Waste Services Consultation Response

Waste Management Officer			Head of Eng. Services	X	Refuse & Recycling Manager	
Description:	44-48 King Street Clitheroe – Dawsons extension and flats				 Ribble Valley Borough Council www.ribblevalley.gov.uk	
Application Ref:	3/2017/1002		Case Officer:	SK		
Response Ref:	AH/18		Issue Date:	01/11/17

Part Ground Floor Plan

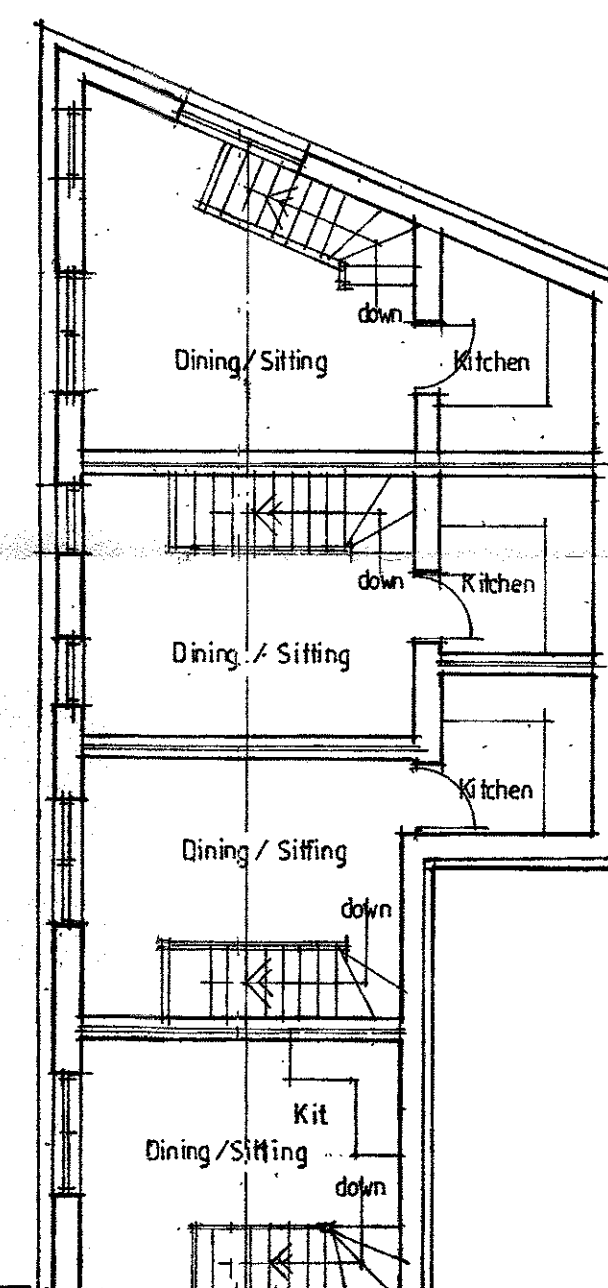
2.2						
3.1	Collection/Storage Provision:	Acceptable:	Yes	x	No	
Assume communal bins for domestic dwellings located to rear of building. No mention in app.
